**EIAR Addendum Report in relation to a Large-Scale Residential Development (LRD) Planning Application at Balbriggan, Co. Dublin**

**09<sup>th</sup> March 2026**

The following Environmental Impact Assessment Report (EIAR) Addendum Report has been prepared by Altamar Ltd. on behalf of Glenveagh Homes Ltd. in response to a Request for Additional Information received from Fingal County Council (FCC) on the 20<sup>th</sup> February 2026 (PF/051/26) relating to a proposed Large-Scale Residential Development (LRD) application (Reg. Ref. LRD0069/S3E) at Balbriggan, Co. Dublin. Specifically, this Report focuses on Chapter 4: Biodiversity of the EIAR submitted as part of the planning application (Reg. Ref. LRD0069/S3E).

The purpose of this Addendum Report is to address Items 2(a)[i]-[ix] of the Request for Additional Information (PF/051/26) relating to Chapter 4: Biodiversity of the EIAR.

Figure 5a. Proposed public lighting layout (sheet 1)

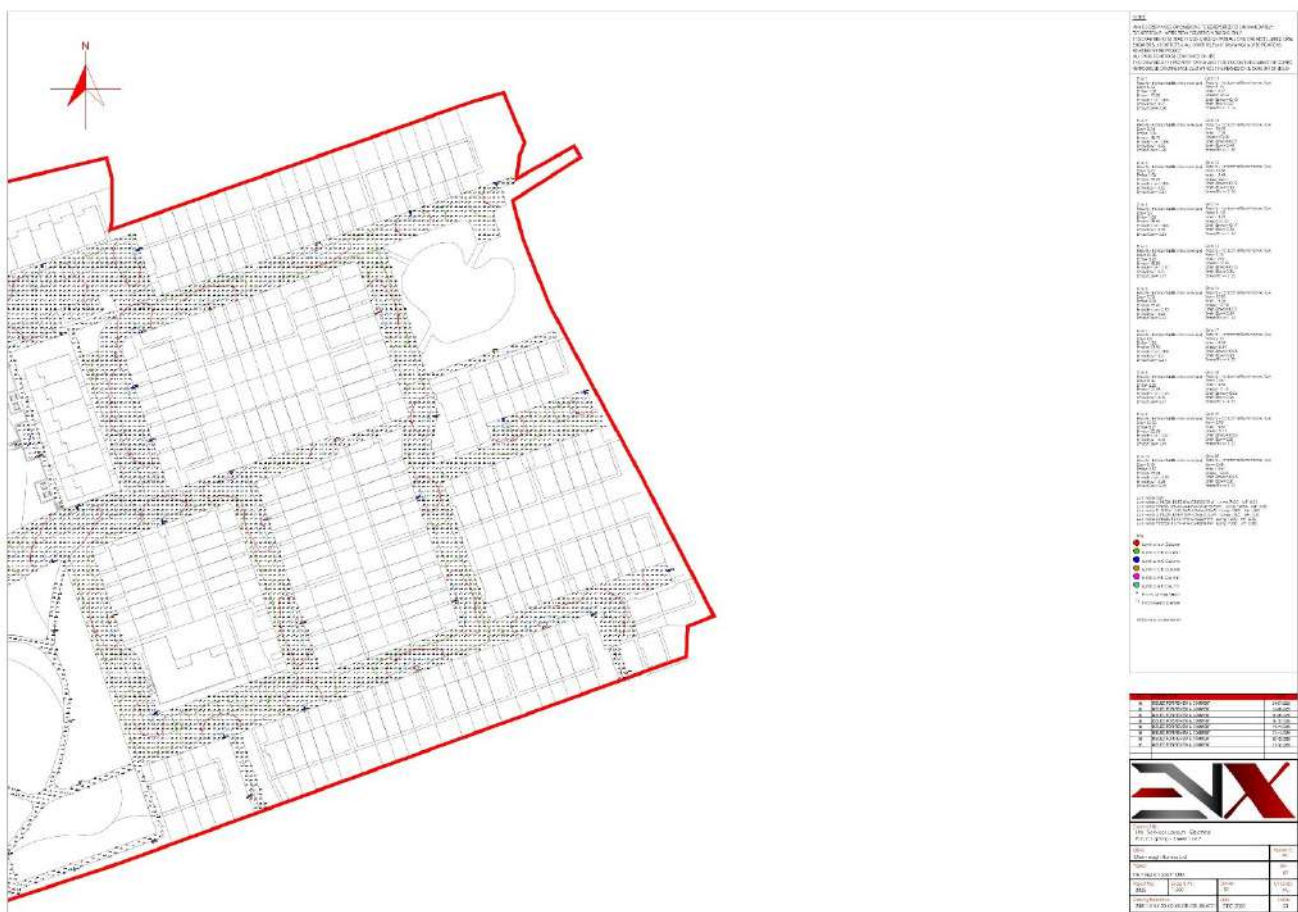
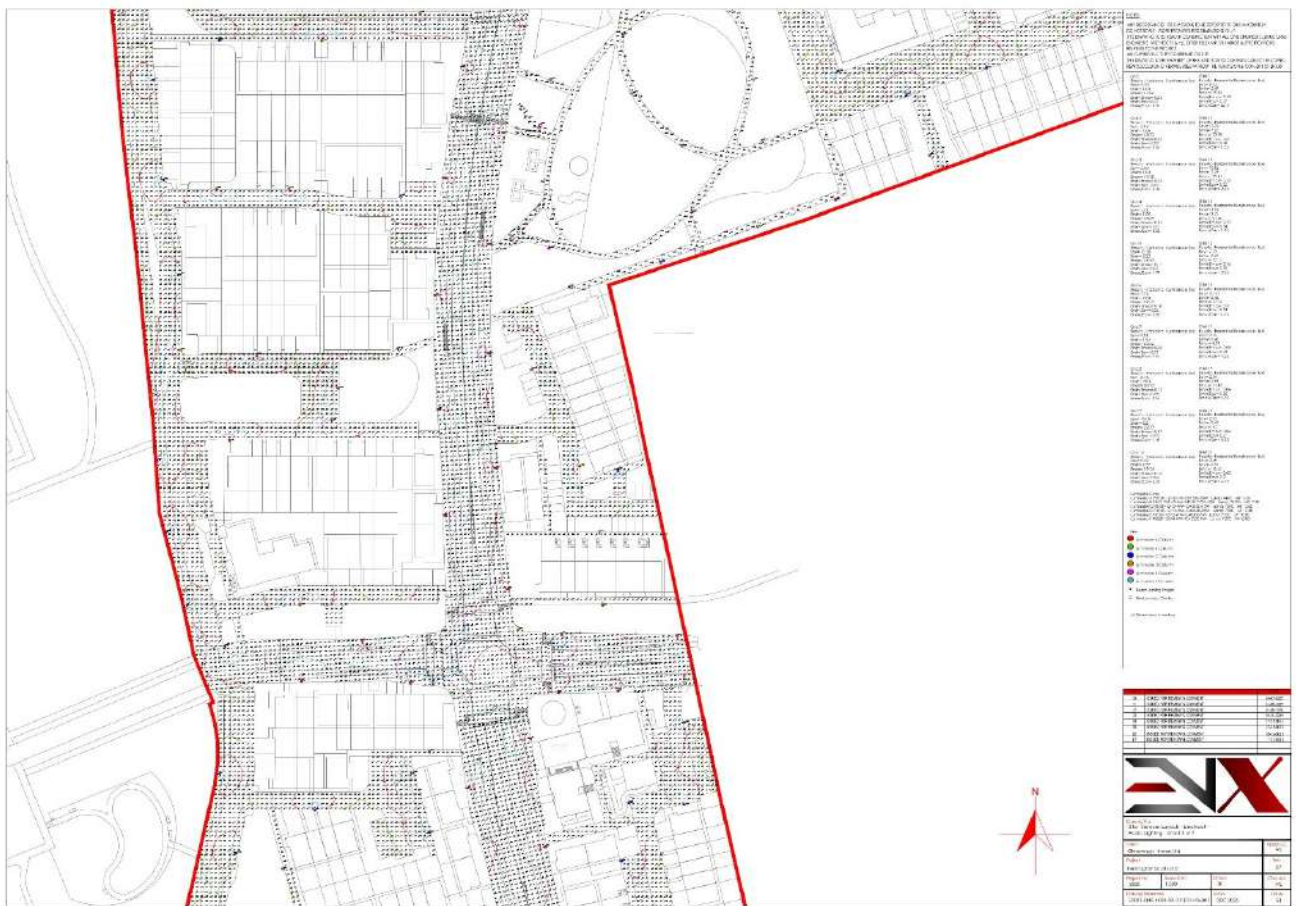
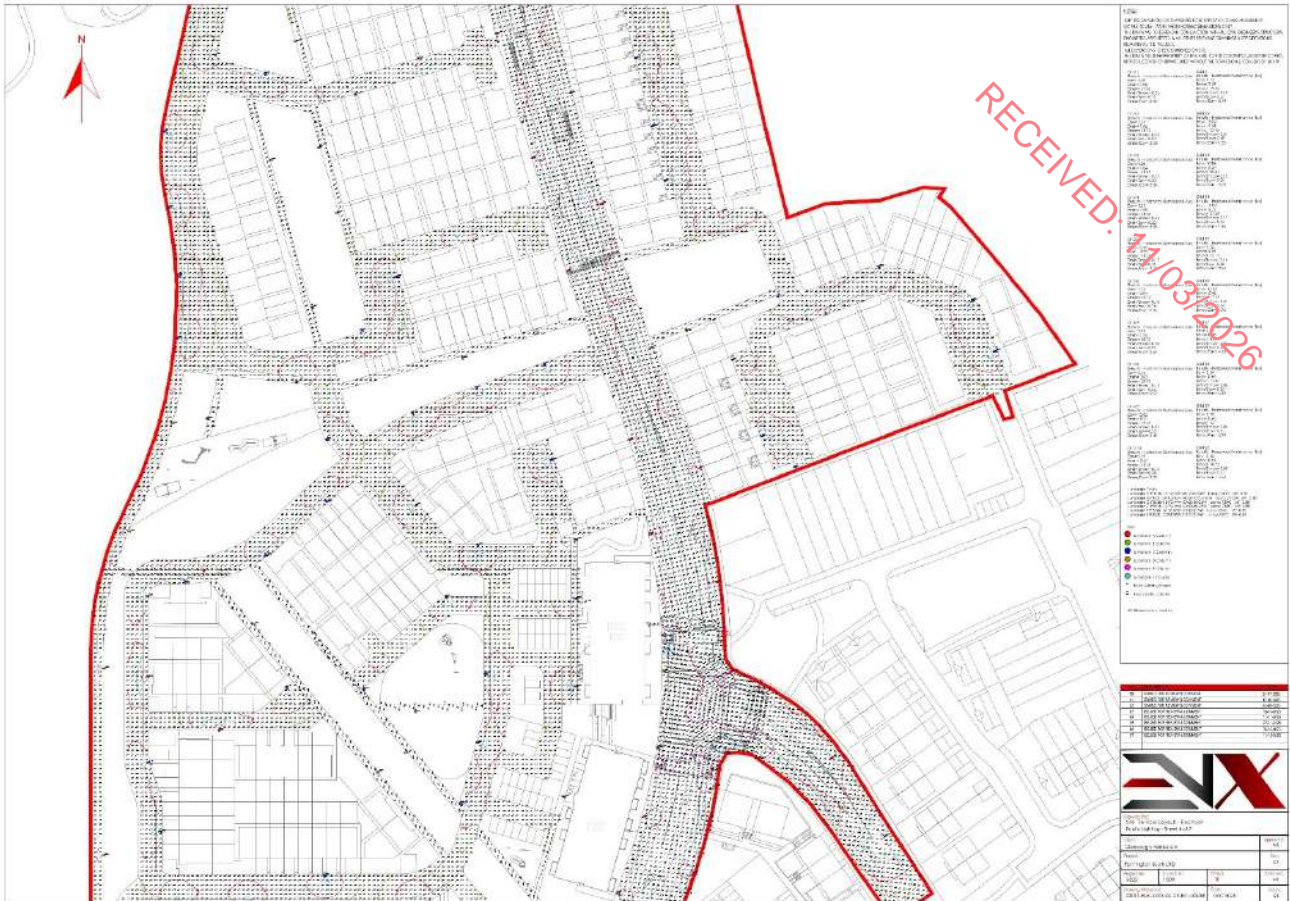
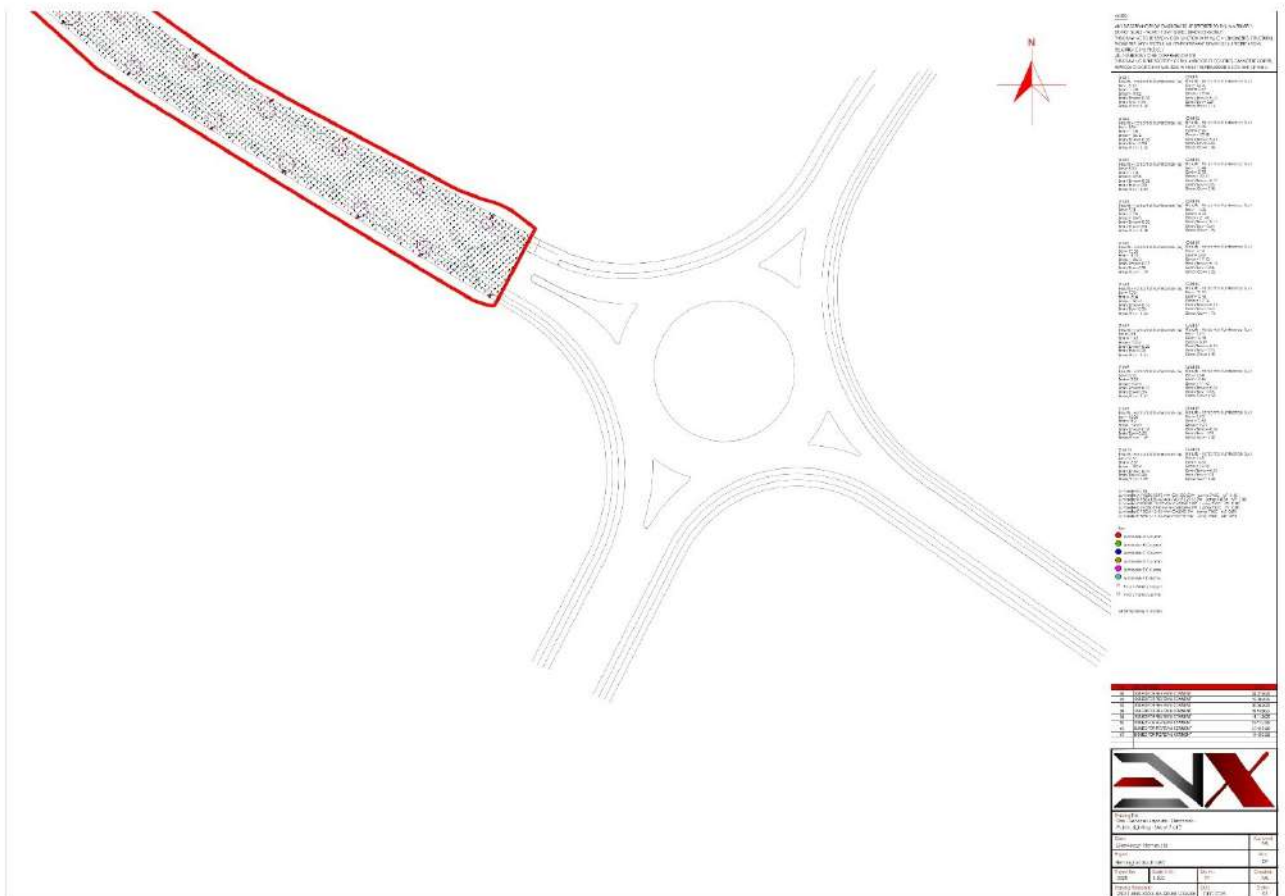
**Item 2(a)[ii]** *'Further details to demonstrate how the proposed lighting design will avoid unintended illumination on key habitats and ecological corridors. Details on the colour, tilt, height, operational hours, cowles or other methods for protecting biodiversity features are required within the chapter.'*

**Altamar Response** Section 4.5.2 has been revised to include the following:

'Lighting Design

*ENX Engineering Consultants outline that the current lighting layout has been designed to Fingal County Council lighting specifications, incorporating the following:*

- *0 degree tilt.*
- *Minimum 6 meter high columns within the estate and the main spine road to 8 meter high columns.*
- *Lighting on the main spine road is natural white 4000K.*
- *Lighting within the estate is proposed at 3000K warm with white fittings.*
- *Lighting designed to a lighting class of P4 (EN13201) with a step back to Lighting class P5 after 12 O'Clock midnight.*
- *Cowels will be provided on lights backing onto ecological corridors and public open spaces.*

*The above lighting design, along with mitigation measures outlined in Section 4.8, will ensure the proposed lighting design will not have a significant impact on local biodiversity. It is important to note that backspill protection has been proposed on lights that could potentially impact on biodiversity features and that the lightspill software utilised to prepare the lighting plan does not have the ability to show the reduced spill as a result of the back spill protection. Therefore, the "worst-case scenario" of light spill is demonstrated in lighting drawings and is an over-estimation. See Appendix 4.1 for further details.'*
